I hope your well. Could we up date the drawing in for approval with attached A-124-01-REV-B there has been a small amendment to the drawing. A small dormer is now required to the rear to allow for head hight for the stairs.

Proposed Loft Floor Plan

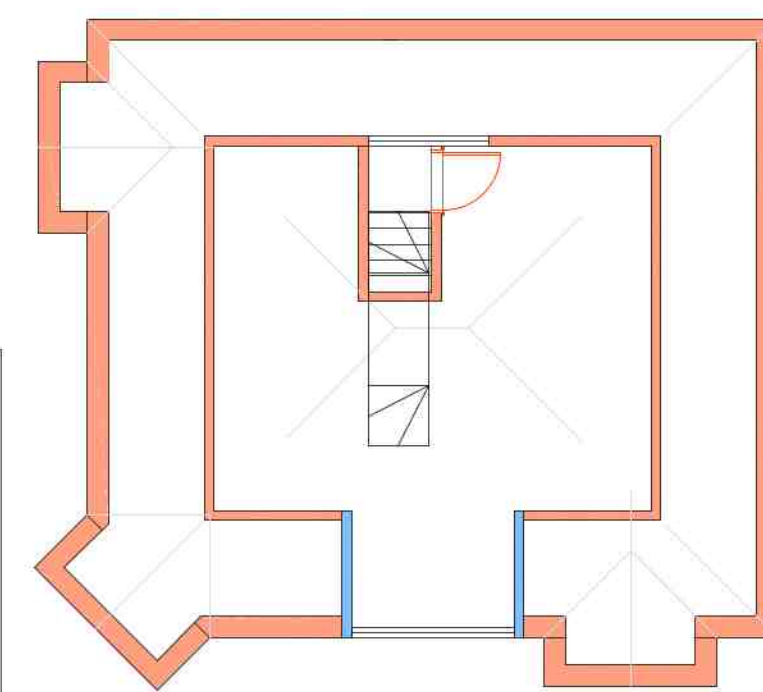
The plans show a proposed larger dormer with a widening of the dormer window. This needs to be shown on a proposed loft floor plan. Please amend.

Thanks you for getting back to us regarding A/97/20/HH. Please see attached drawing A-124-01-REV-A with amended description, loft floor plan and block plan with dims as requested. Also attached completed CIL form. Anything else you may need please don't hesitate to contact me.
